MMC: FW: Shaws TCP (CMP)

Here is a revised CMP as developed by Shaw Brothers. As you will see in the notes, they have identified lane widths and provided much greater detail as it relates to signs, crosswalks, etc. Hopefully this will suffice along with the team's previous responses and the PG to establish a pre-construction meeting ASAP so that this work may begin.

See a link to a revised construction management plan for the Congress Street enabling work for MMC below. If you can take a look ASAP, that would be great. We're trying to get them moving so that they/we can complete this work in early summer.

TITLE
**PLAN & PROFILE:
GILMAN STREET/
CONGRESS STREET
ENABLING WORK**

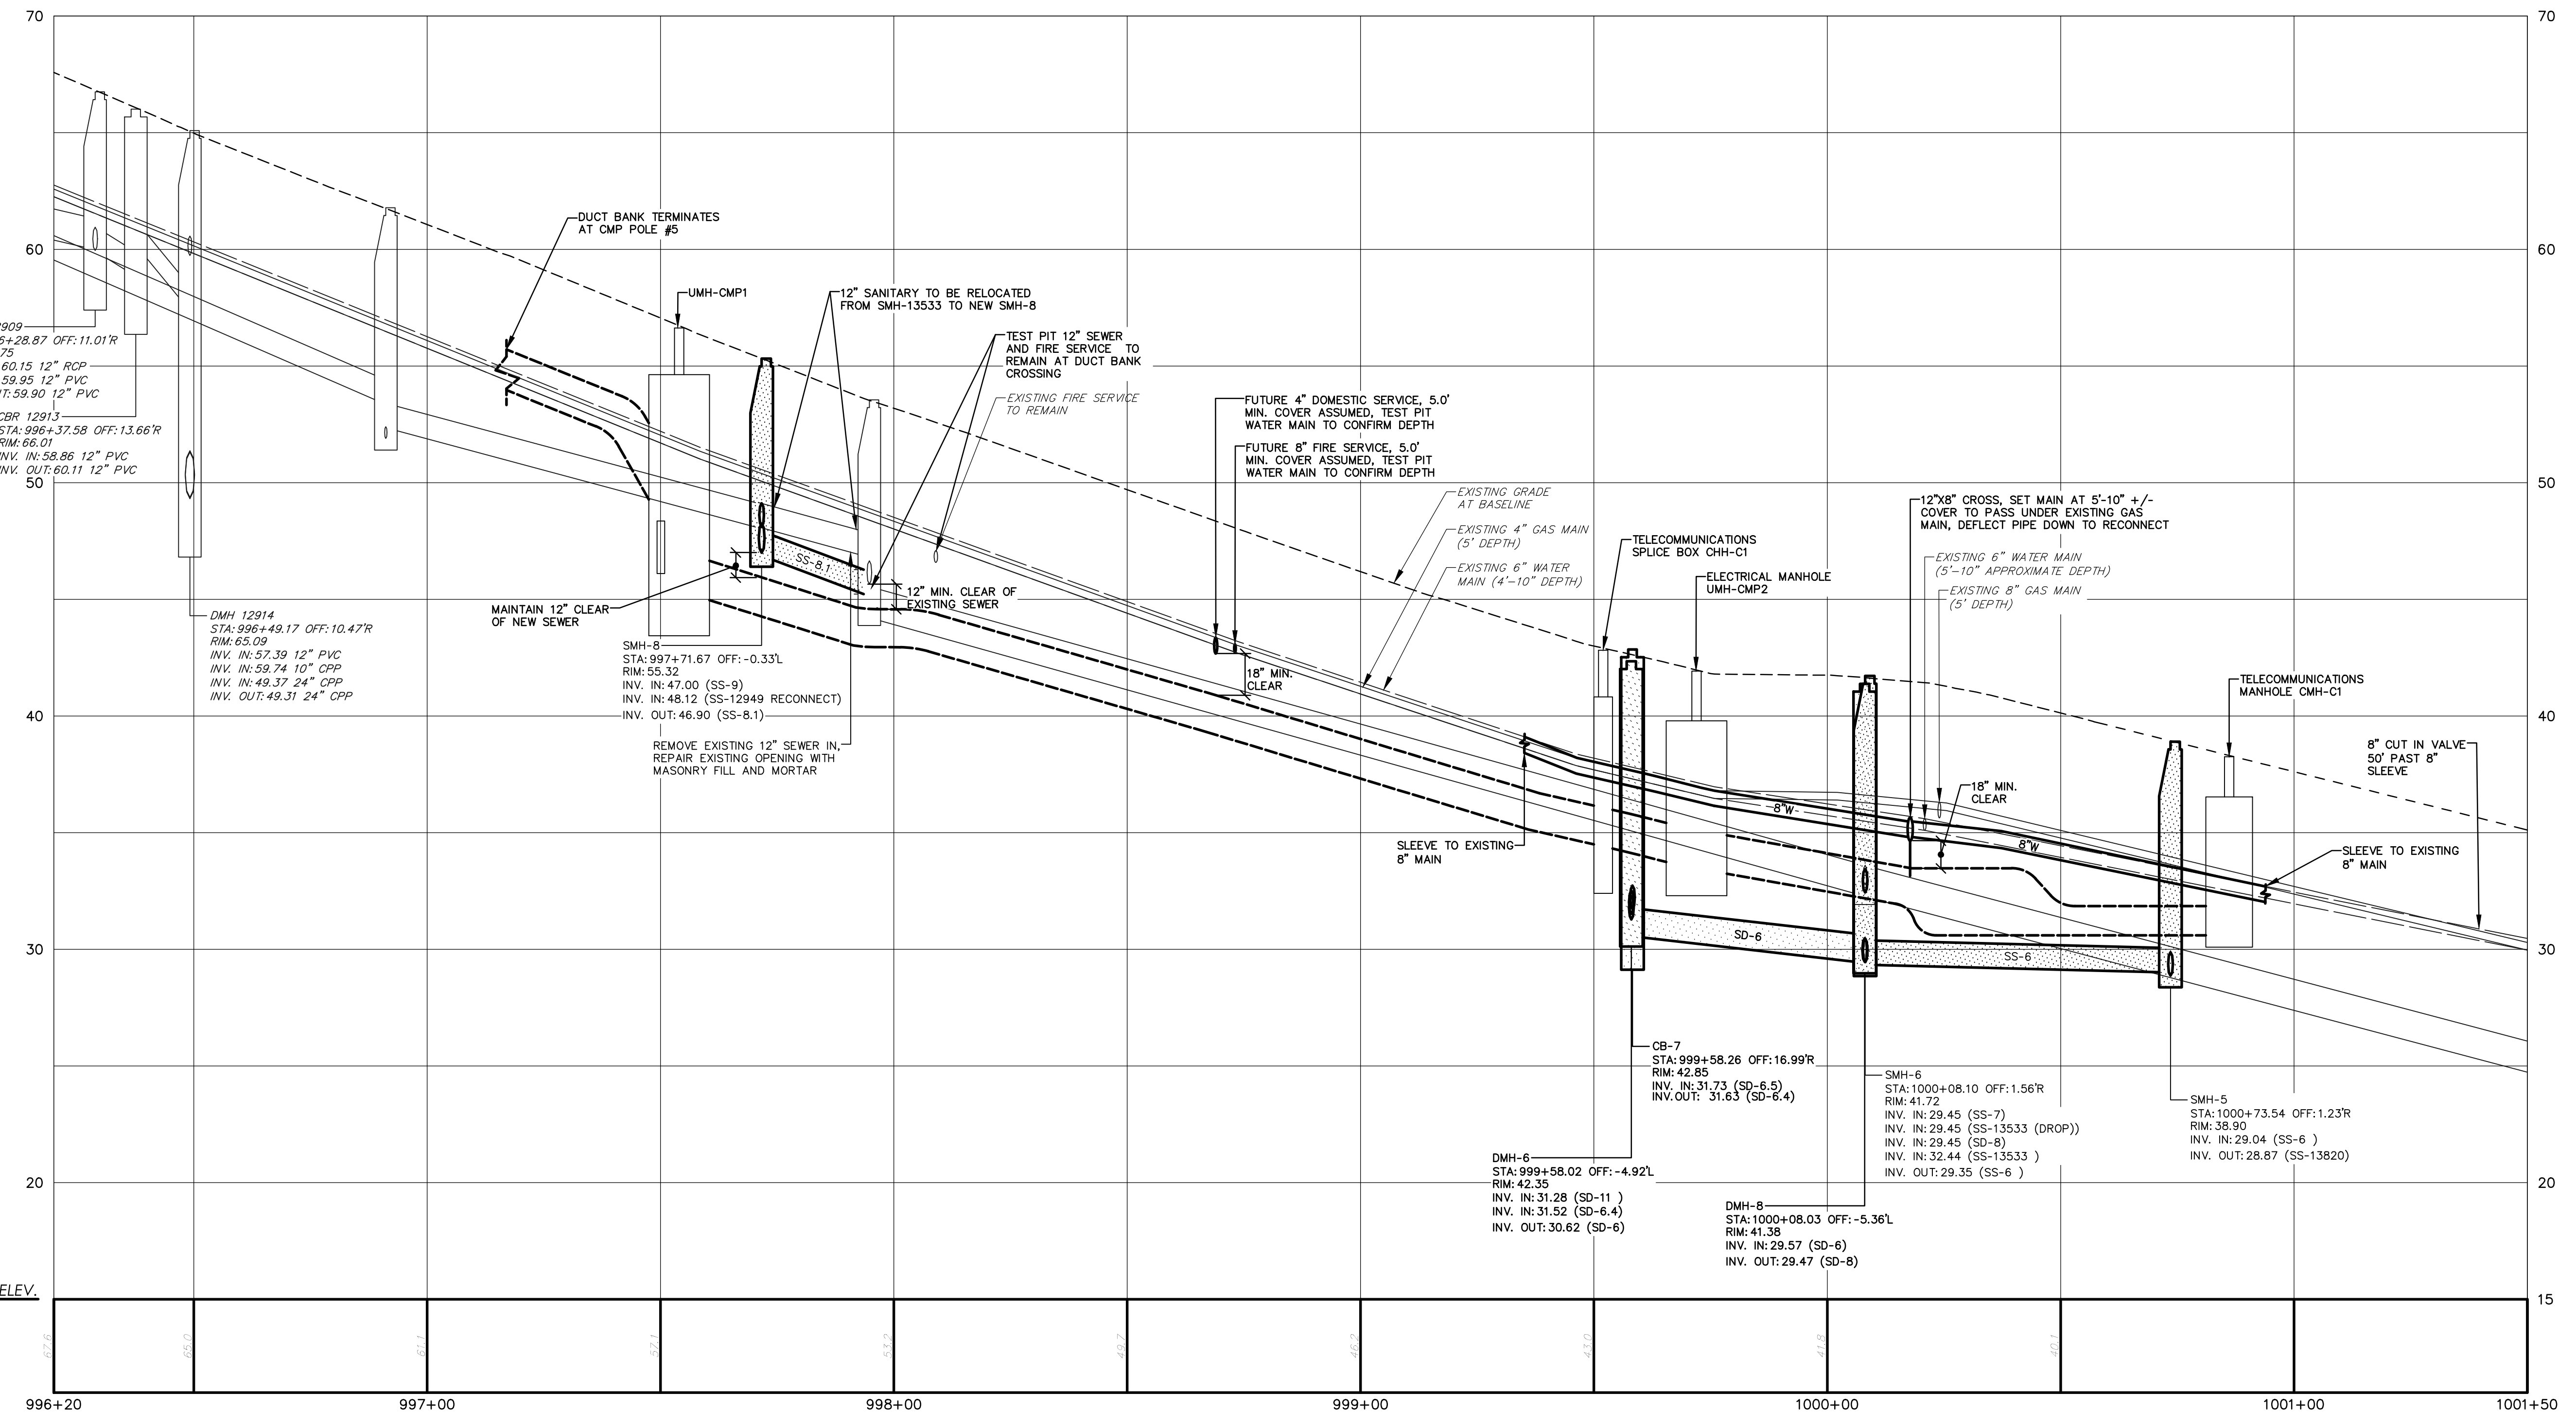
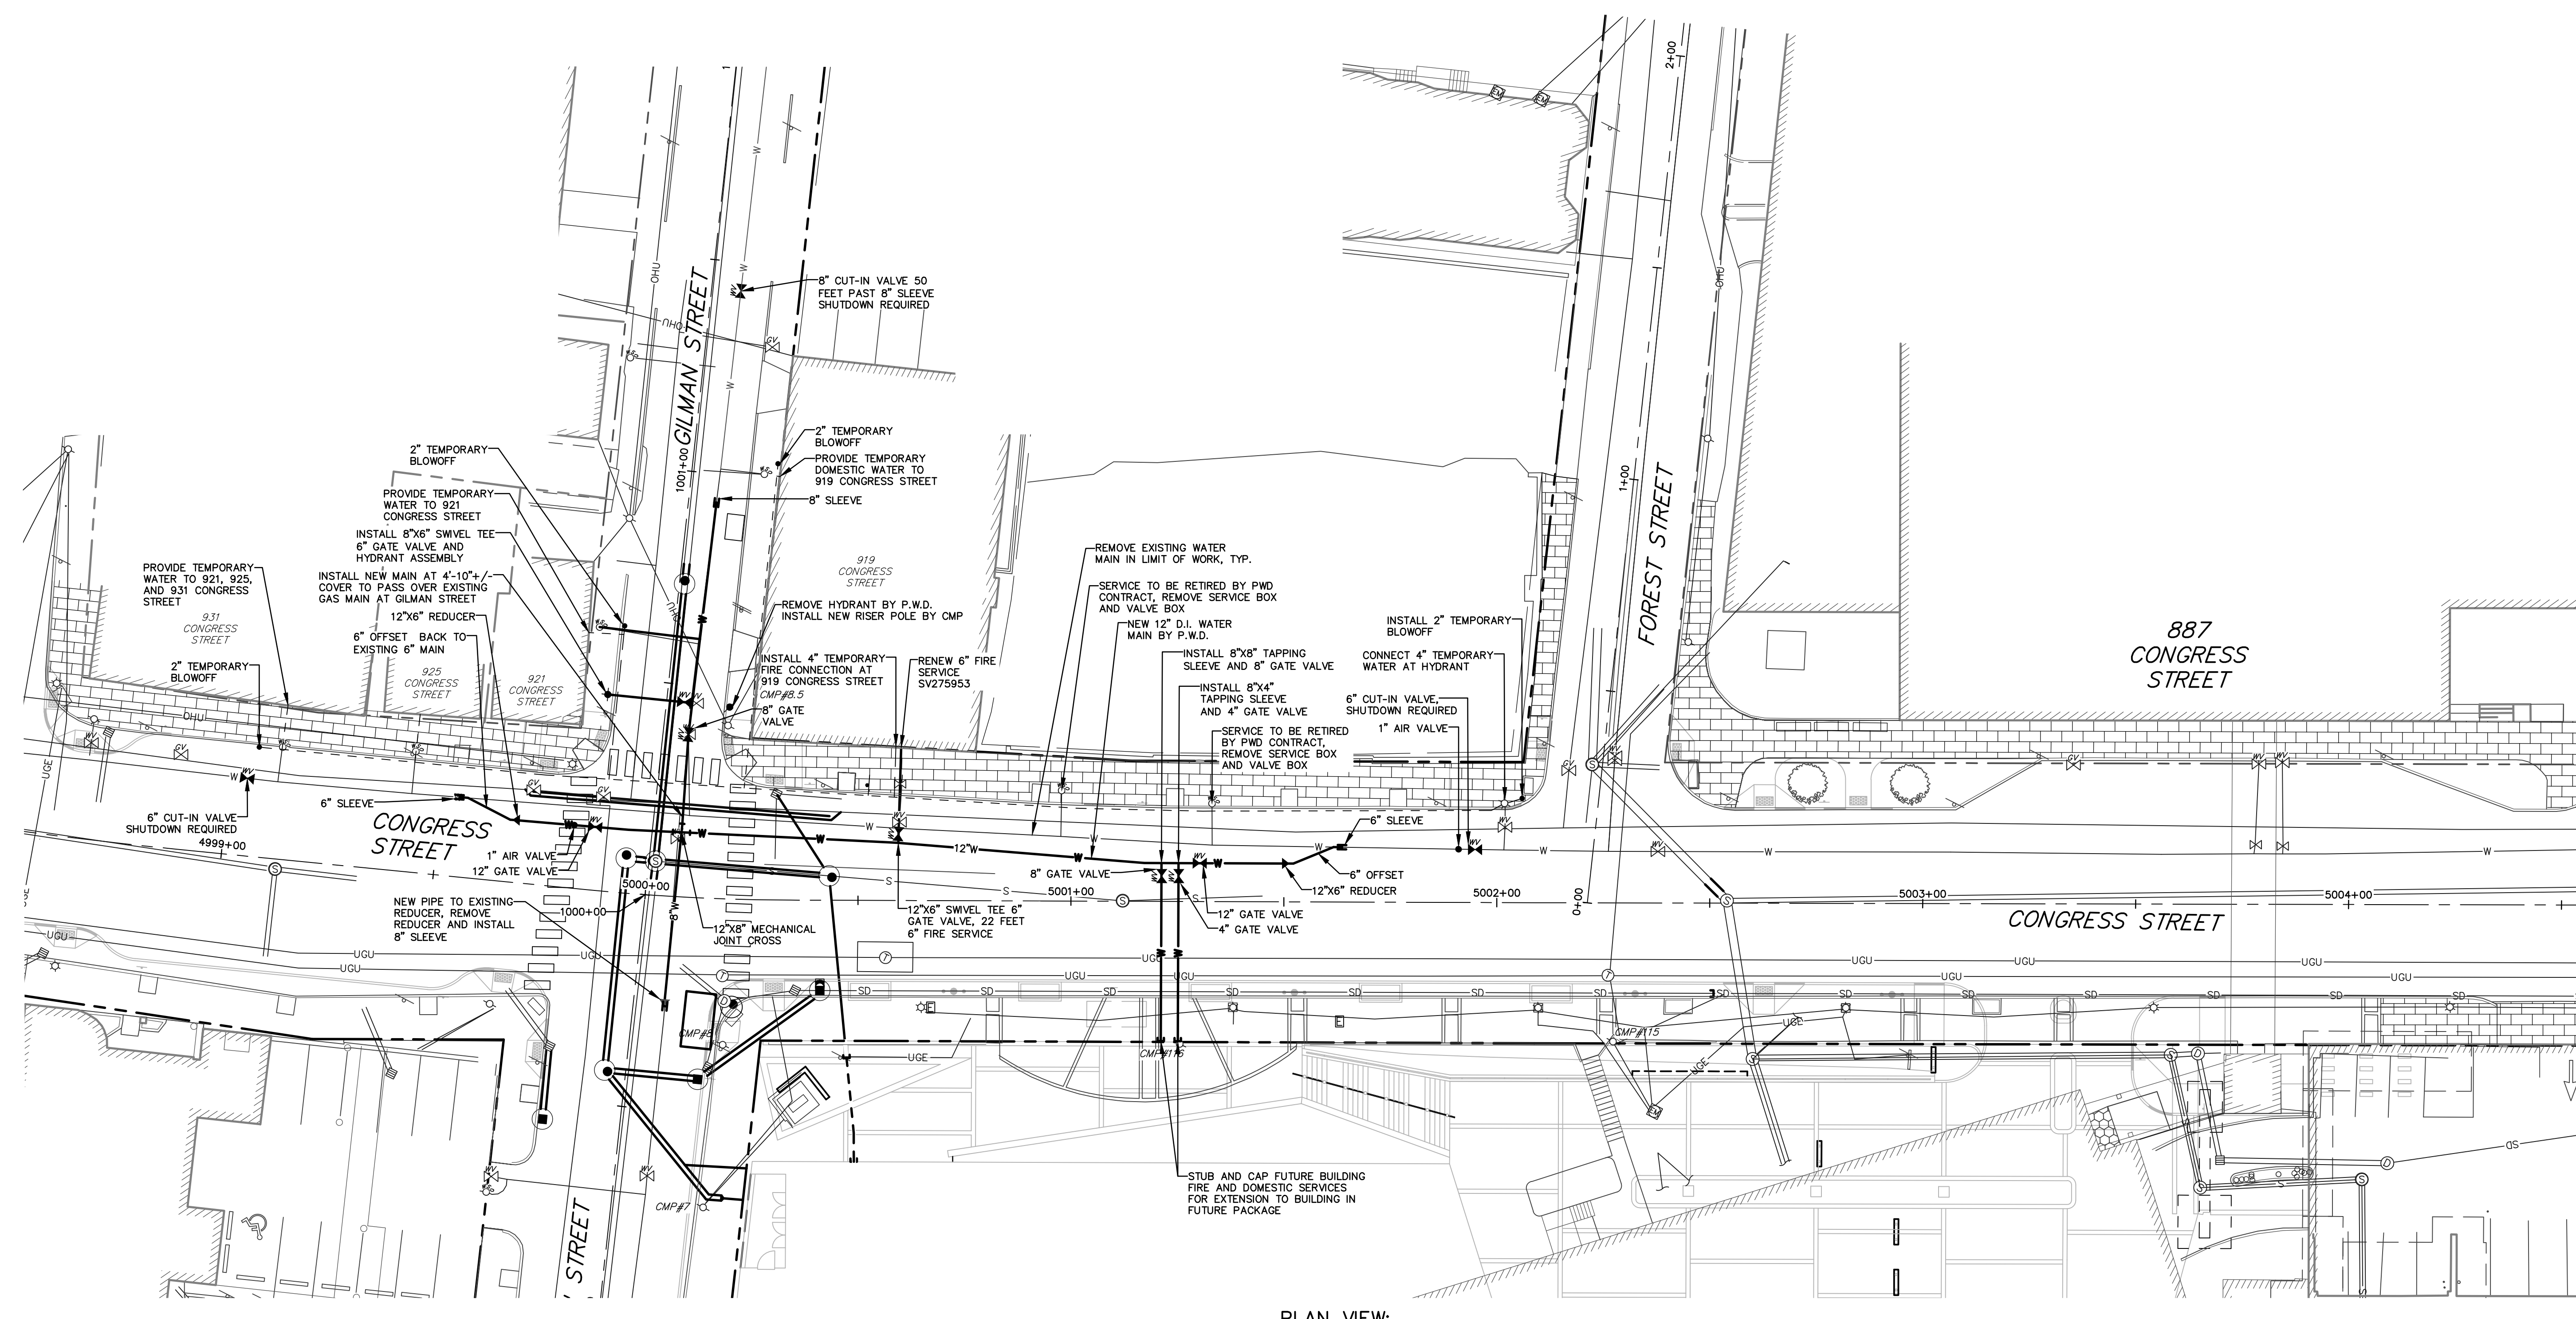
- Manholes and other structures located within the street should be placed as close to the centerline as possible, or aligned with the center of a vehicle travel lane, where at all possible. To the extent practical, proposed manholes should be shifted to align with these goals, possibly including, but not limited to, DMH-1, DMH-2, SMH-7, and SMH-8, all of which appear to be within the wheel path of a vehicle. Note that bicycle lanes should be kept clear of manholes where at all possible. DPW does not expect the applicant to make significant changes to the utility plan to accommodate this request; however, any minor adjustments that can be made will be advantageous to roadway conditions.

SMH-7 and SMH-8 are the two structures mentioned in the comments that are part of the enabling work. These new sewer manholes are located on the existing city sewer that is to remain. Relocating the structures is not possible without relocating the City sewer to a new location in the street. The manhole covers can be rotated to move cover as far as practicable out of the wheel path, but it is not practical to relocate the structures off of the existing sewer location.

These are new separated storm drain manholes. The new storm drain was set to be parallel to the city's existing sewer to remain, in the middle 1/3 of the street and centered between an existing sanitary sewer to remain and an existing telecommunications duct bank. The structures were set to maintain 4' to 5' minimum clear between the new manholes and both of the existing utilities. Moving the structures one way or another encroaches the clearance to one utility or another. The manhole covers can be rotated to move the cover as far as practicable from the wheel path.
